From: Sue Howell
Sent: 16 May 2017 16:57
To: Andrew Wood
Subject: RE: Y/5/17 - Open Space s106 contributions request

Public Open Space

CONCEPTUAL LAYOUT

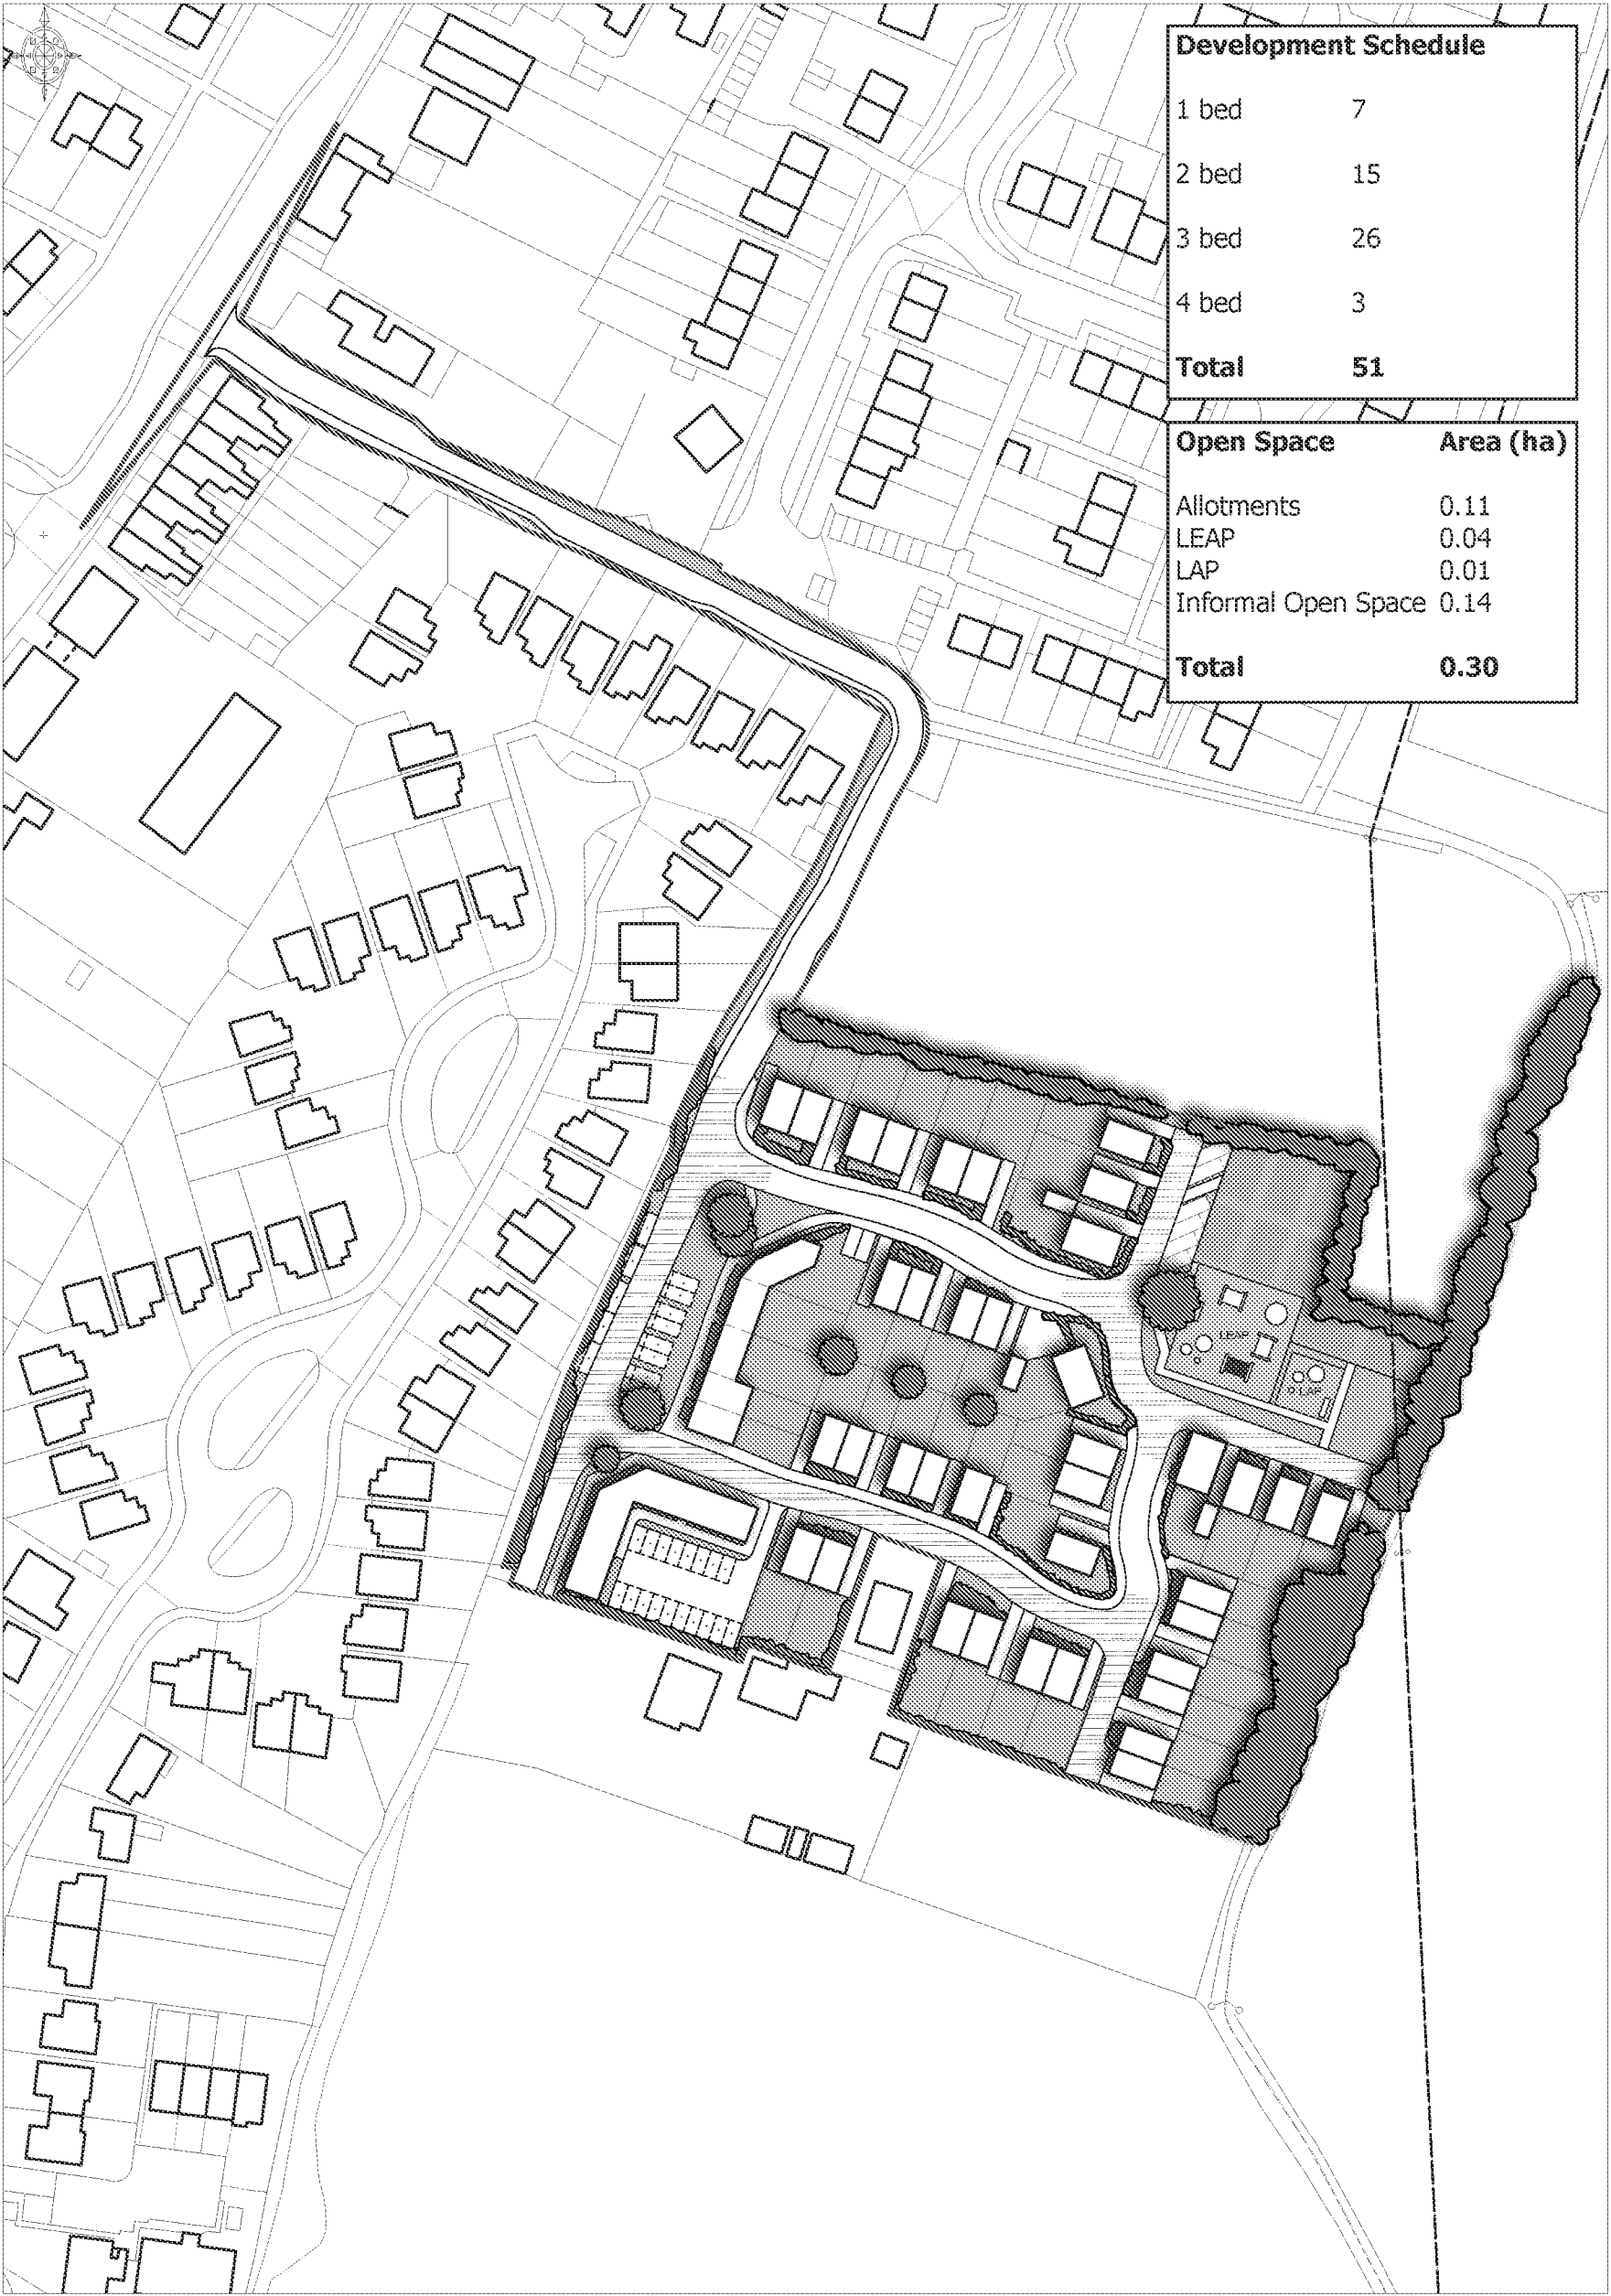
Under our existing SPG then there is a requirement of .29Ha which this site is just reaching, however under new FIT standards this would require .39Ha. from the layout shown all of the open space appears to be taken up with allotments and play provision, which actually leaves very little as true Public Open Space. Therefore my comment that it would be preferable for open space on-site and offsite contribution for the play, muga and allotment element instead.
